Info Only: Engineering comments are in blue text.

# TOWNHOMES AT WESTERN

## LOT I, CIMARRON SOUTHEAST FILING NO. 2C, SECTION 7, TOWNSHIP 14 SOUTH, RANGE 65 WEST of the 6th PRINCIPAL MERIDIAN, EL PASO COUNTY, COLORADO

PCD File No. SF2410

TJW	DATE: 21 MARCH 2024
RDH	DRAWING NO: - TOWNHOME
230905	SHEET: 1 of 3

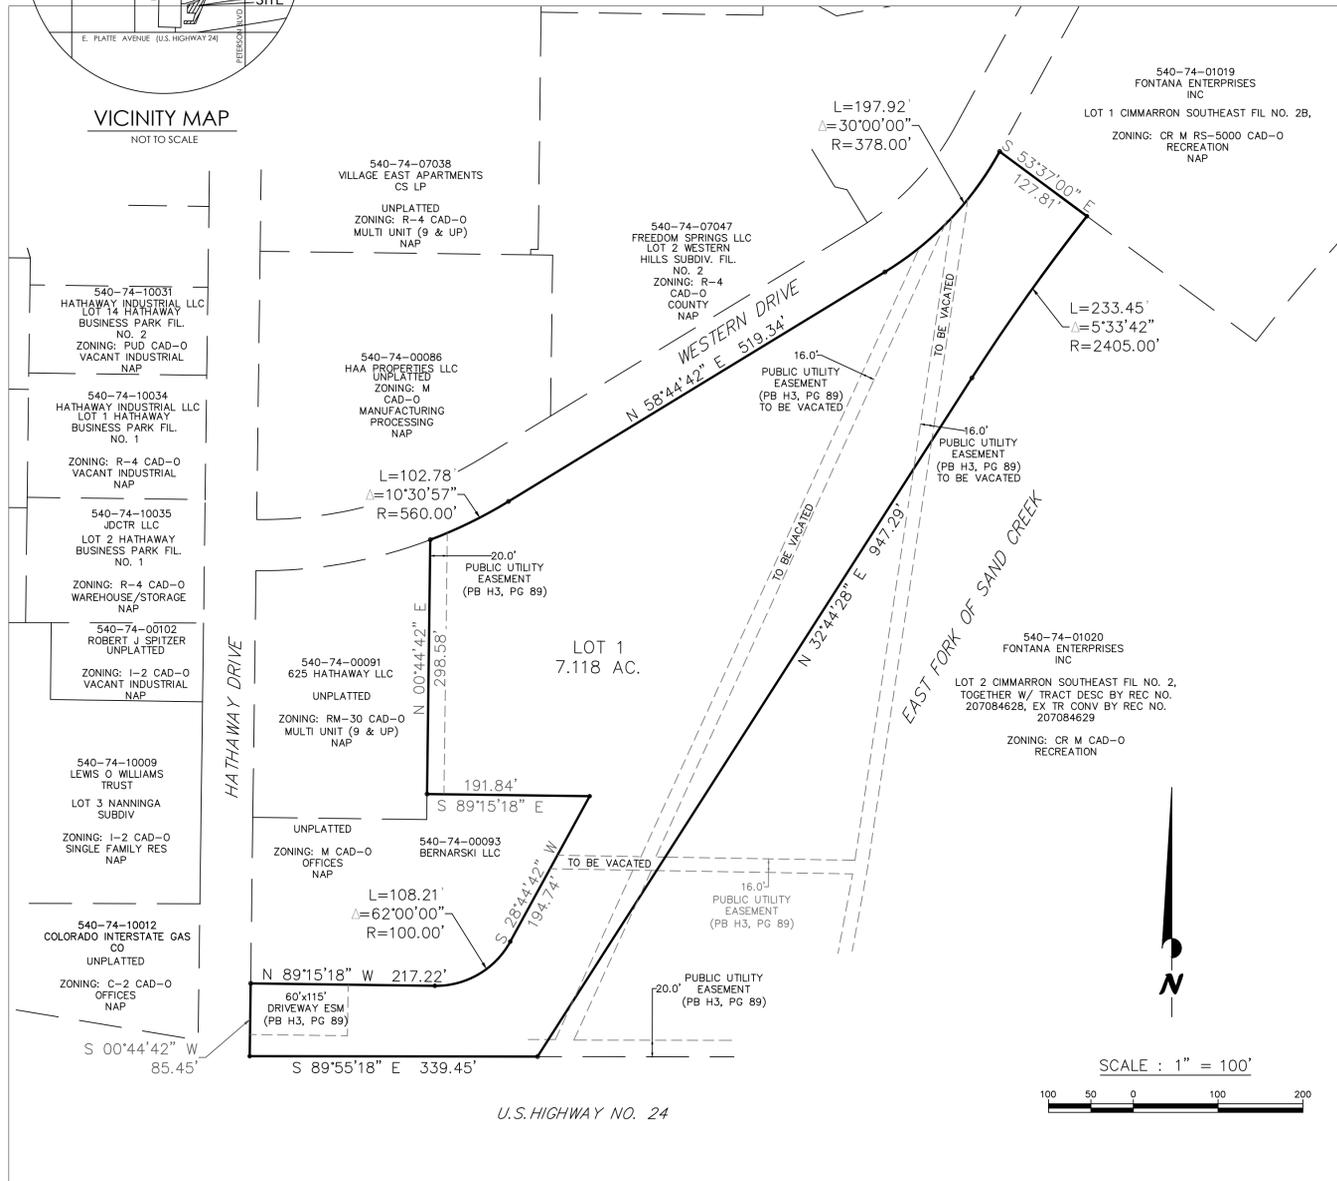
Please include the following note: The individual lot purchaser(s) shall be responsible for final design, construction, and maintenance of private detention pond/water quality BMP(s) as described in the approved Preliminary/Final Drainage Report for this subdivision. Final design, construction drawings and drainage report updates for the detention pond/water quality BMP(s) for each lot shall be provided with Site Development Plan submittals. The detention pond/water quality BMP(s) shall be constructed and completed prior to the issuance of any building permits for the subject lots. The subdivision developer is responsible for providing financial assurances as indicated in the Subdivision Improvements Agreement and Estimate of Guaranteed Funds for the detention ponds/water quality BMPs. All detention ponds/water quality BMPs shall be constructed prior to the release of said financial assurances. Individual lot purchasers shall enter into a Private Detention Basin / Stormwater Quality BMP Maintenance Agreement and Easement ("Agreement") prior to the issuance of any building permits for the subject lots. In the case that the developer constructs the detention pond(s), the developer shall enter into an Agreement for each pond constructed.

Please include the following note: No structures or uses are permitted within designated "Floodplain" or "Park and Open Space" areas. (Modification of this note may be allowed if the plan approved by the Floodplain Administrator, provided this creates no conflict with approved plans or conditions.)

Please include the following note: Unless otherwise indicated, all side, front, and rear lot lines are hereby platted on either side with a 10 foot (use 5 feet for lots smaller than 2.5 acres) public utility easement unless otherwise indicated. All exterior subdivision boundaries are hereby platted with a 20 foot (use 5 feet for lots smaller than 2.5 acres) public utility and drainage easement. The sole responsibility for maintenance of these easements is hereby vested with the individual property owners.

Please include the following note: Lot \_\_\_\_ (or Tract \_\_\_\_ ) (or entire property) of this property is subject to a Private Detention Basin/Stormwater Quality BMP Maintenance Agreement and Easement as recorded at Reception No. \_\_\_\_\_ of the records of El Paso County. The \_\_\_\_\_ HOA (or Owner or District) is responsible for maintenance of the subject drainage facilities. Watershed Dam Note (To be used when the subdivision affects or located in areas which are inundated by the high water line of a watershed dam, or downstream in the impacted area.)

DRAWN BY:	TJW	DATE:	3/22/2024
CHECKED BY:	RDH	DRAWING NO.:	- TOWNHOME
JOB NO.:	230905	SHEET:	2 of 3

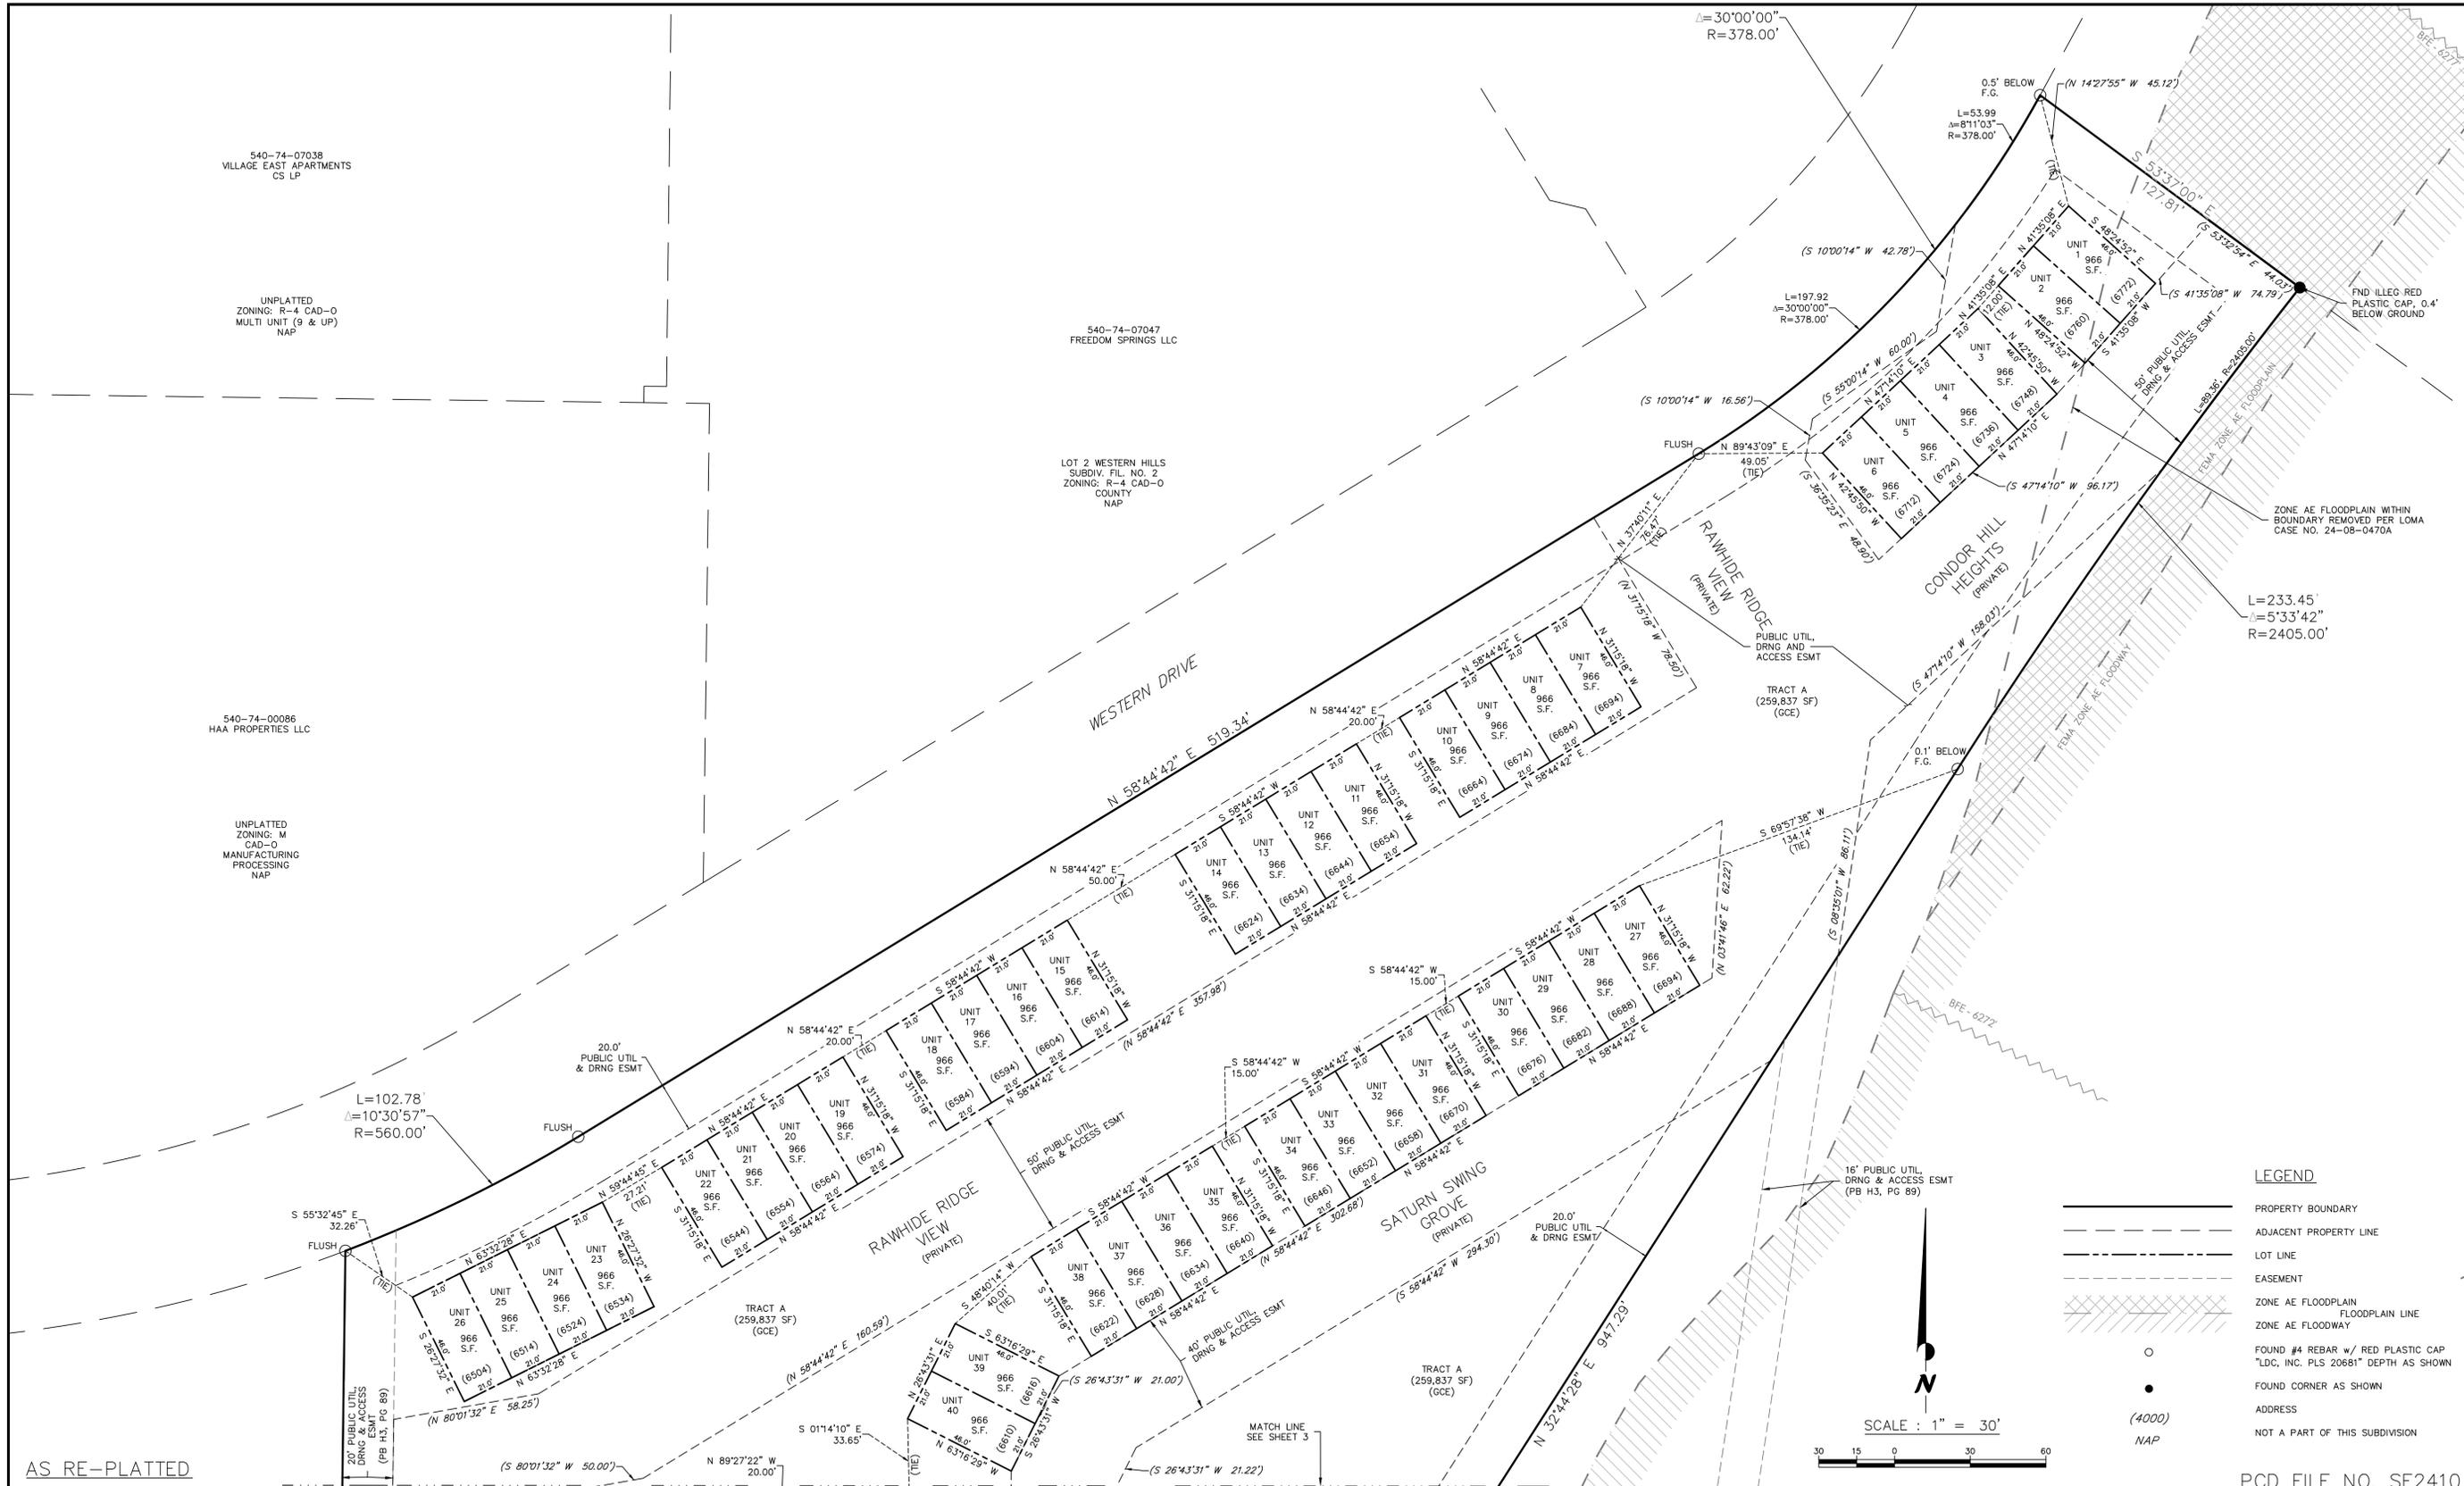
Floodplain should be a no build area, unless a CLOMR/LOMR is being proposed for work in the floodplain.

Include hatches in legend or label them on plan

Label easement

Please show drainage easement for the detention pond, and outfall pipe.

DRAWN BY:	TJW	DATE:	3/22/2024
CHECKED BY:	RDH	DRAWING NO.:	- TOWNHOME
JOB NO.:	230905	SHEET:	3 of 3

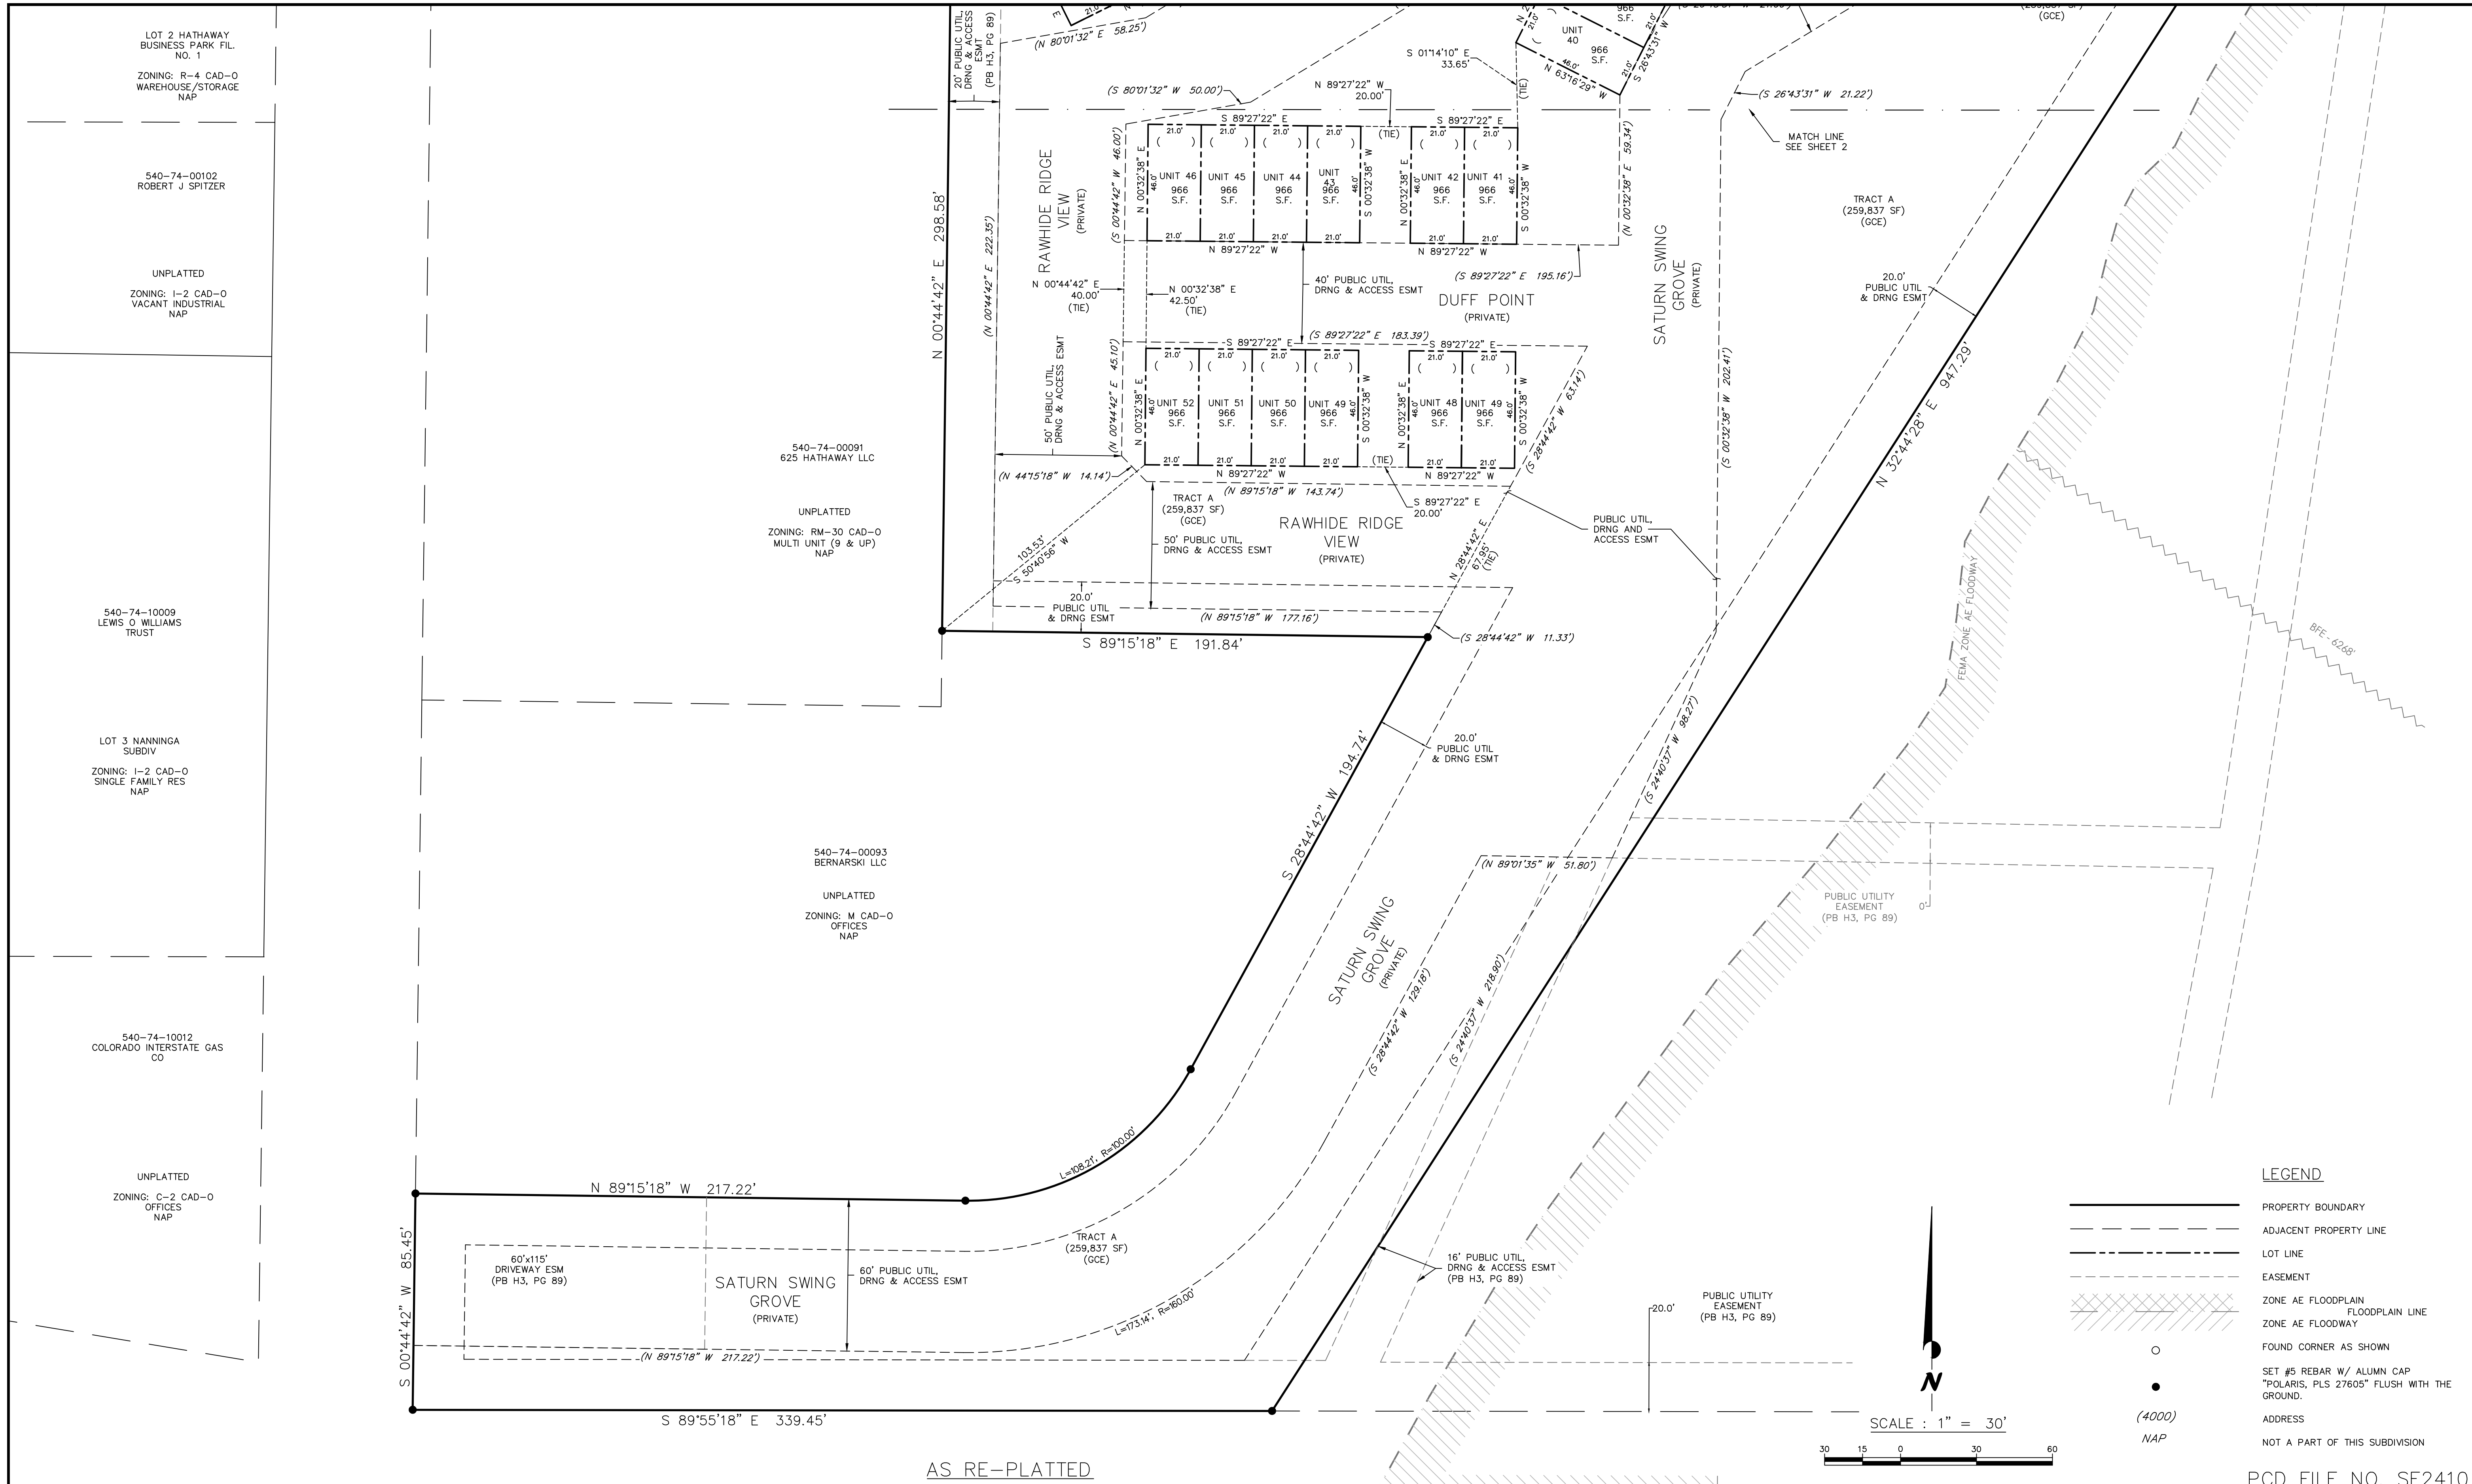
Floodplain should be a no build area, unless a CLOMR/LOMR is being proposed for work in the floodplain.
